Submission for Job: #2770 Site 4 - Commercial Retail Residential redevelopment
https://majorprojects.onhiive.com/index.pl?action=view_job&id=2770

21 December 2010

Re: Major Project MP08_0244 Environmental Assessment (EA) for Construction of a Mixed Use Commercial, Retail and Residential Development at 23-37 Lindfield Avenue and 11 Havilah Avenue, Lindfield

A	DA	20	B
disc	stage	dwg no	revision

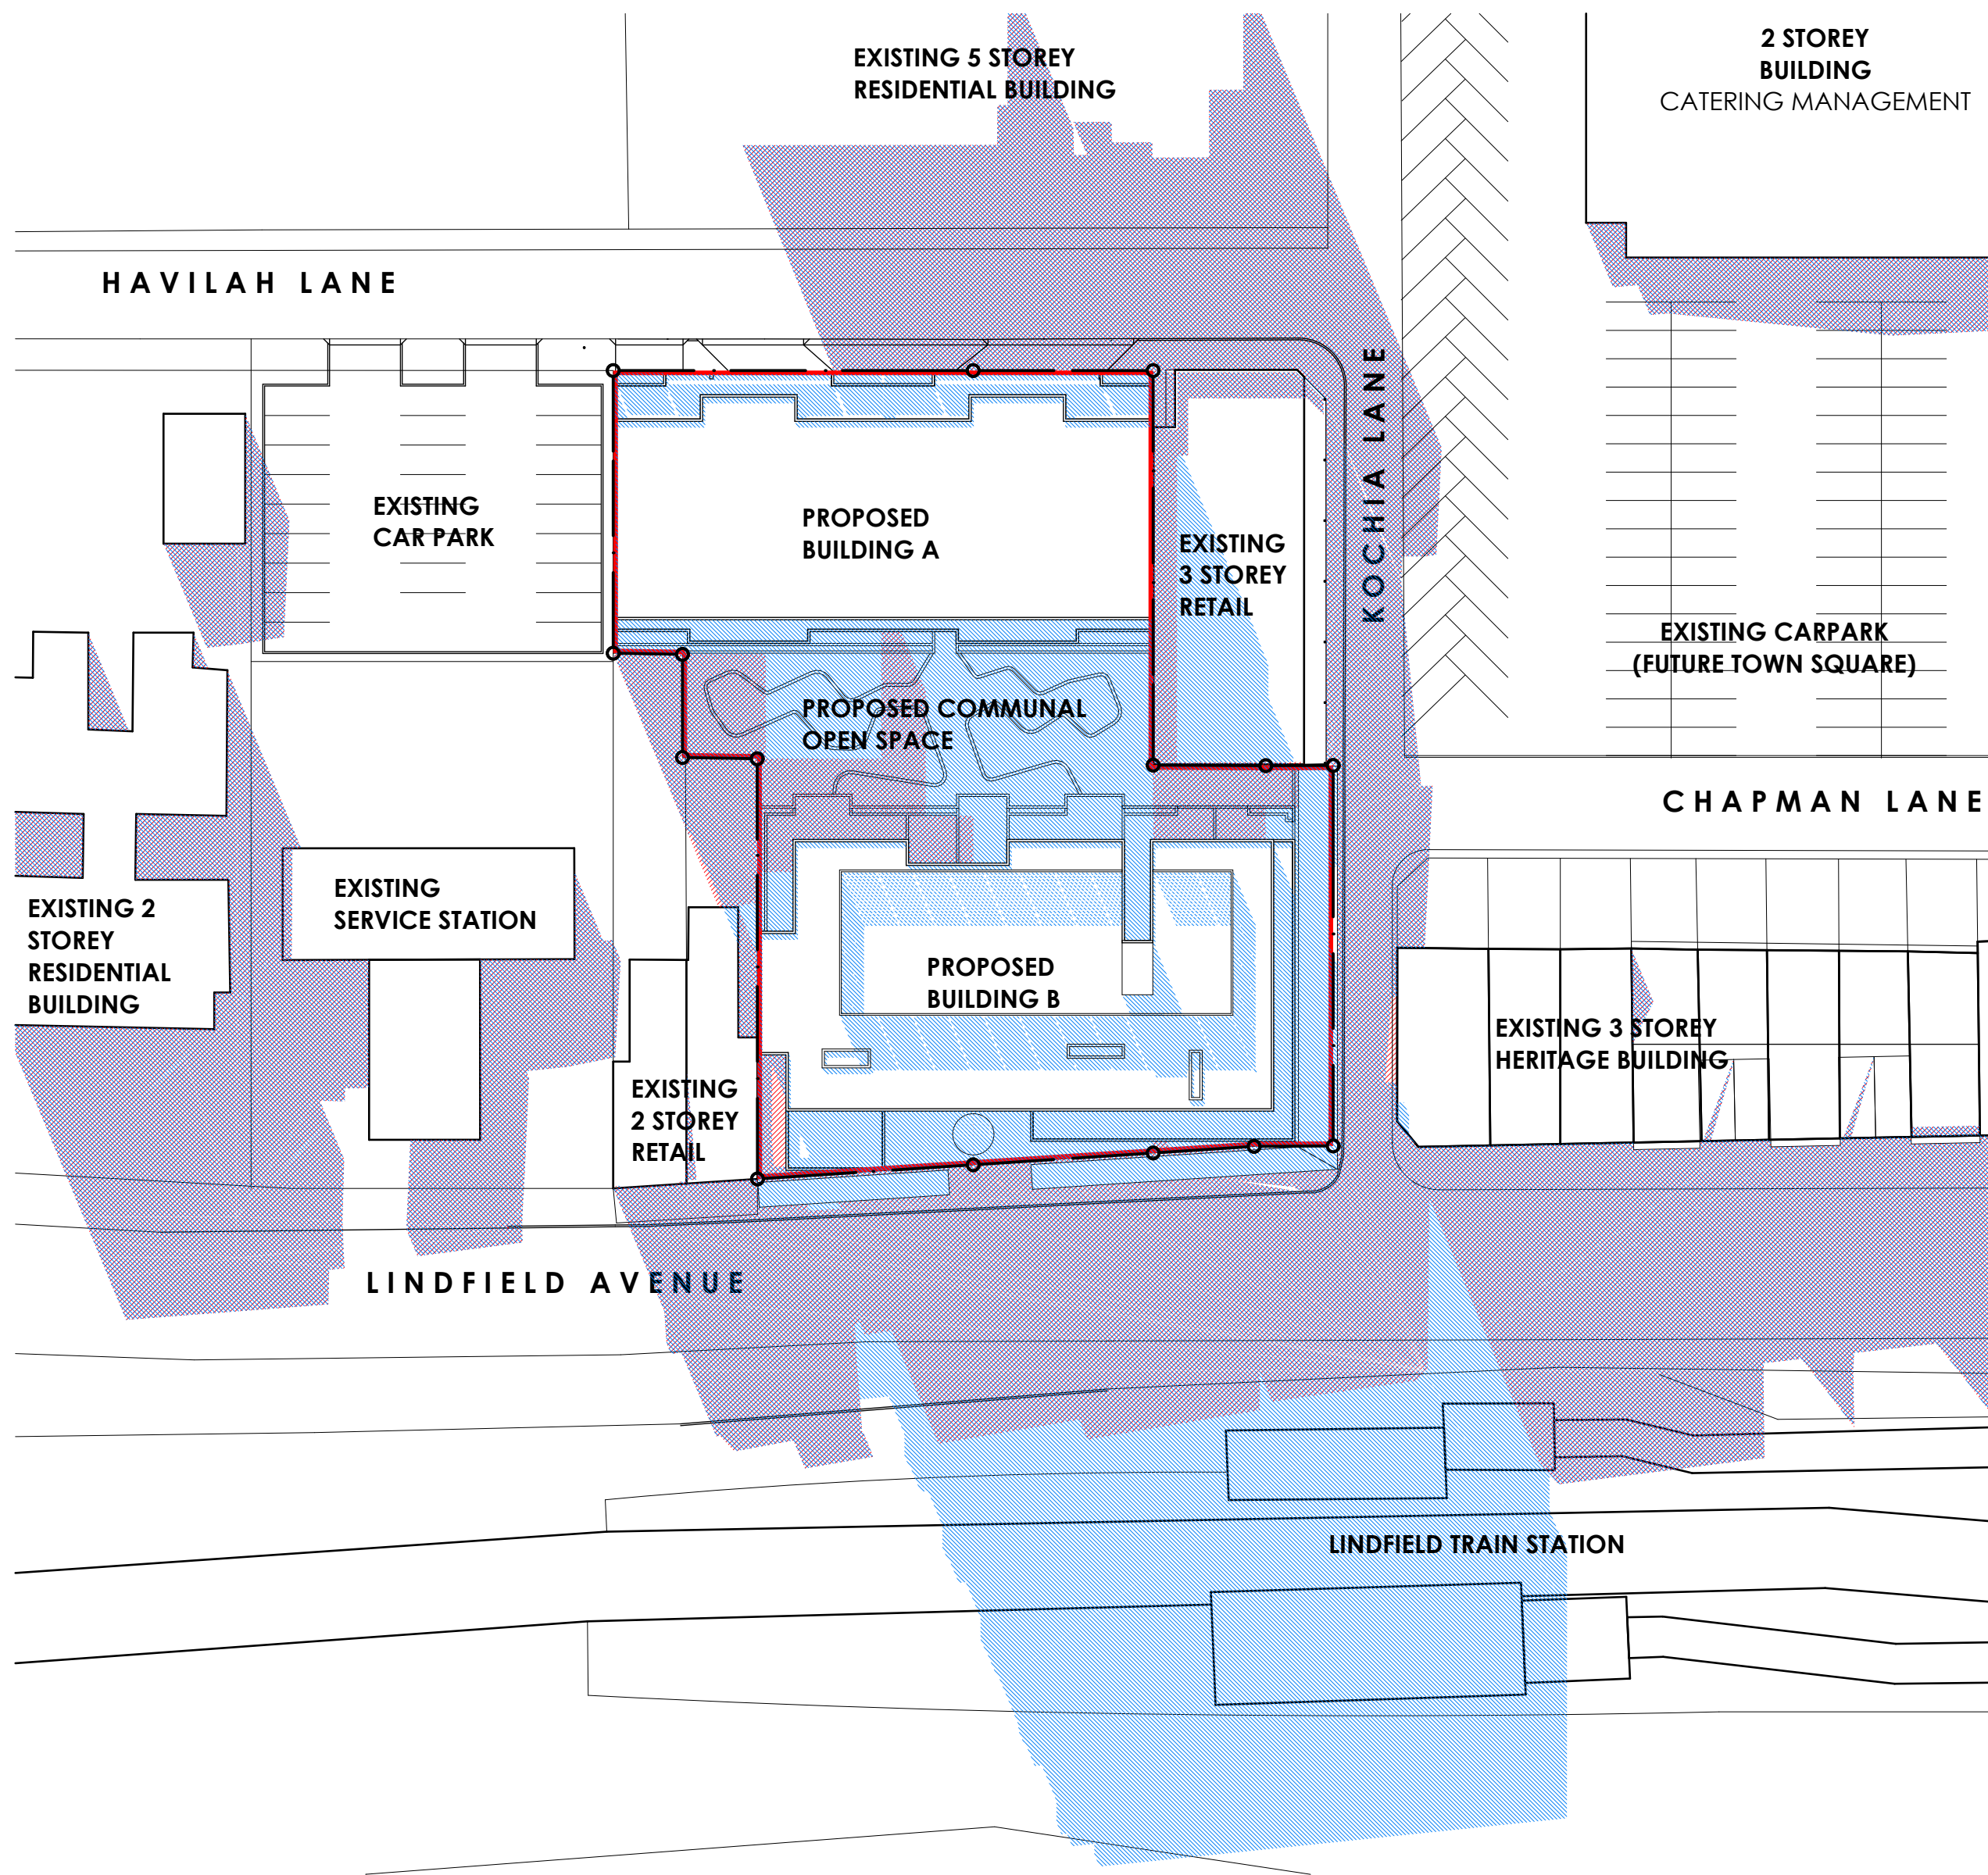
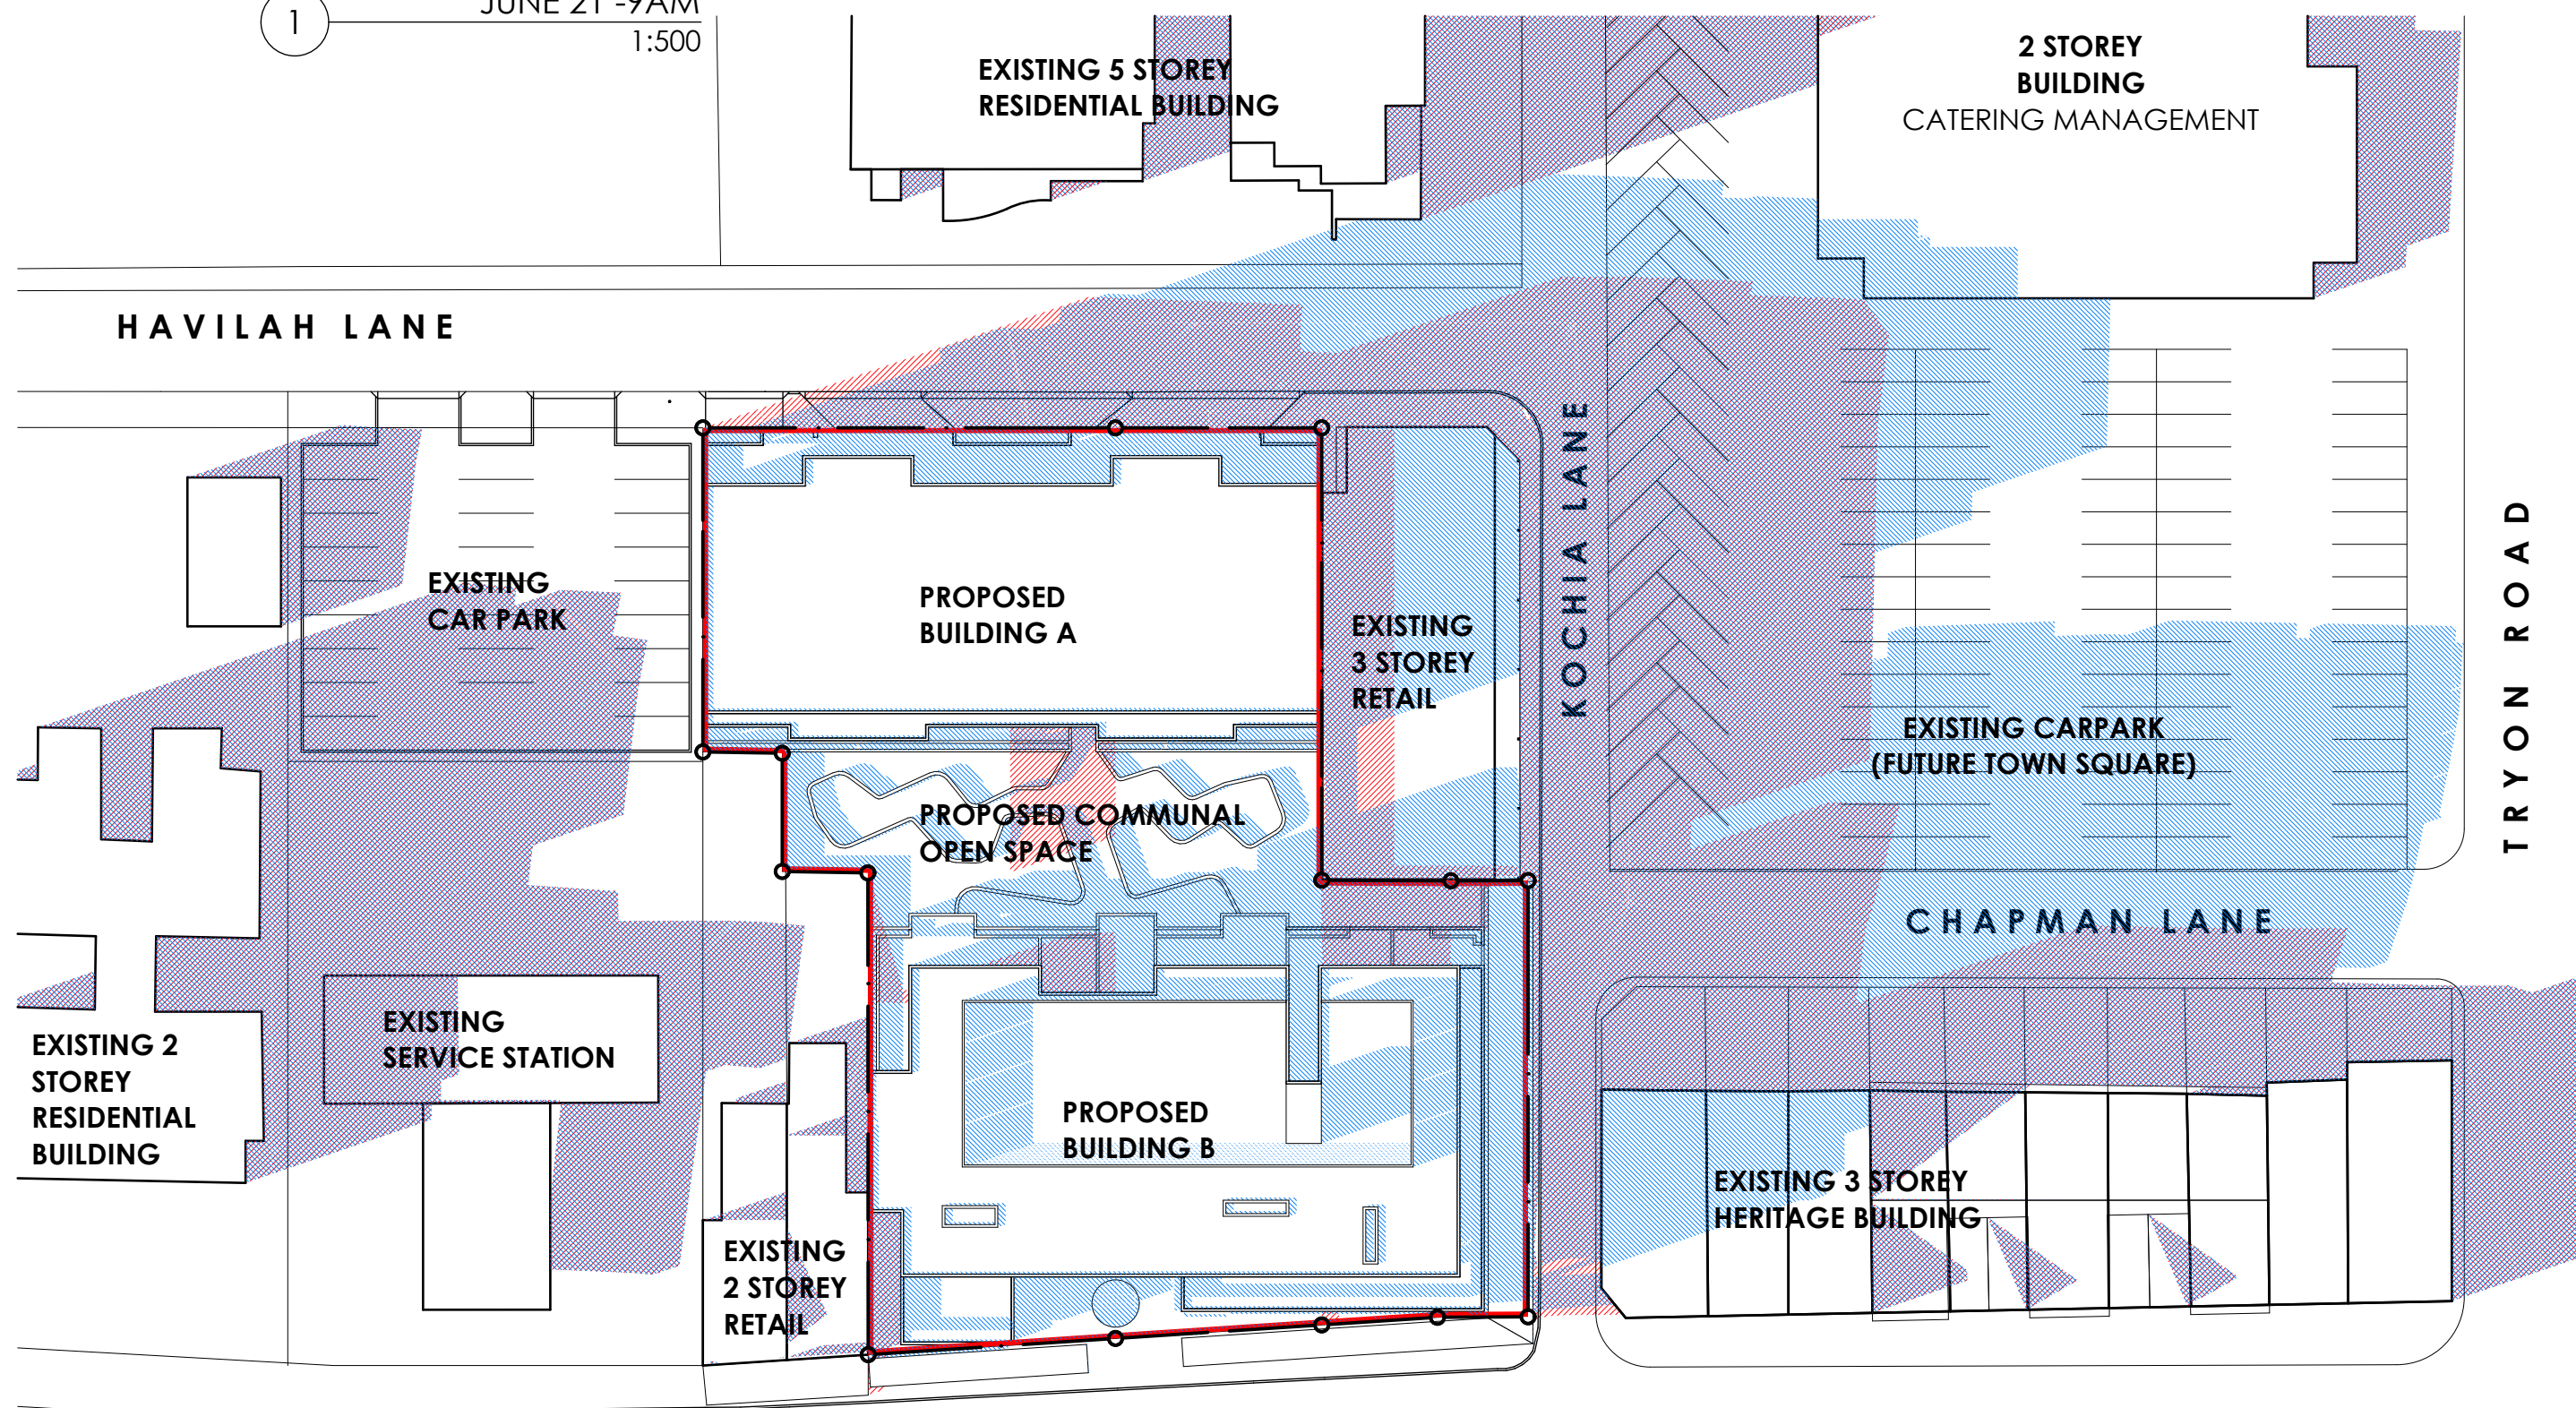
- The Lindfield Avenue building at 7 storeys will cast **significant shadow on the railway station (which is an open station)**, affecting a larger number of commuters as per the March, June and September Shadow Diagrams.

- The development will cast significant shadows on future open space in the proposed town centre, causing loss of amenity to the broader community, as per the June and September Shadow Diagrams.

b) Maintain development to a maximum of 5 storeys, in line with the broader Lindfield environment.
